**KIRKLEES METROPOLITAN COUNCIL  
INVESTMENT & REGENERATION SERVICE**

**DELEGATED DECISION TO DETERMINE PLANNING APPLICATIONS**

Reference No:	<b>2024/62/90838/E</b>
Site Address:	5, Hopton Hall Lane, Upper Hopton, Mirfield, WF14 8EP
Description:	Demolition of existing garage and erection of outbuilding with associated external alterations
Recommending Officer:	Edward Cheseldine

**DECISION - REFUSED**

Topographical Site Plan
1:100

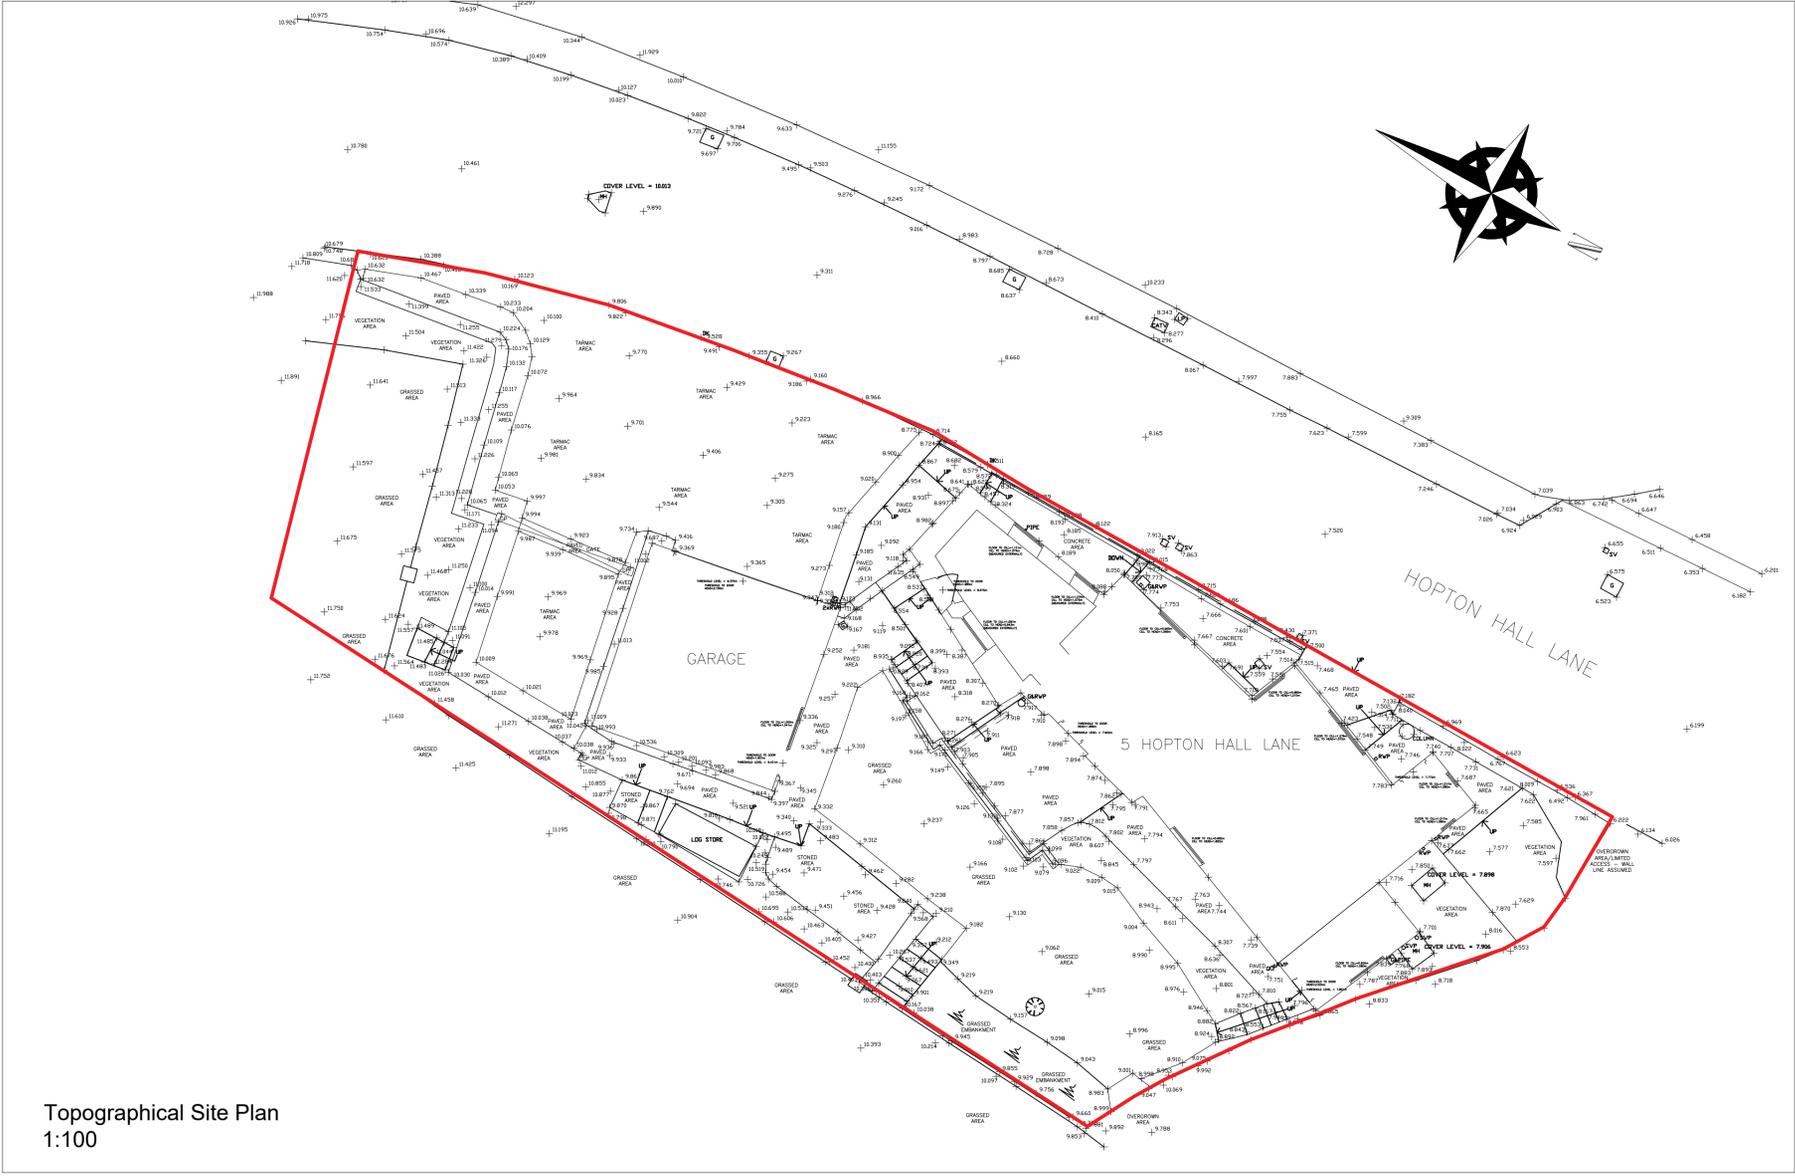
which is ~5.60m, views to the side of the garage open out onto an open countryside setting. The current proposal has a width of ~8.45m, there is a high-pitched roof of considerably mass. Its footprint is elongated in comparison to the existing garage and implementable extension whilst being positioned further to the south. Due to the lower ground level of the site, compared to the topography of the field to the rear, the open view of the field will be screened which reduces the sense of openness. In effect the dwelling with the walling proposed and original building will create an extended continuation of development significantly reducing the open aspect in this location. The development proposed would therefore have a greater impact to the essential characteristic of the Green Belt which is its openness.

In terms of a spatial assessment, development will be sprawled across the site, extended far beyond the built material as it stood in 1948. The planning unit will therefore have extended southwards by a significant distance which is, in part because of the separation of the garage from the main building and its elongated form. It would form disproportionate additions over and above the size of the original building due to the continuous form and development far beyond its original footprint. It would appear only marginally below the ridgeline of the original building group.
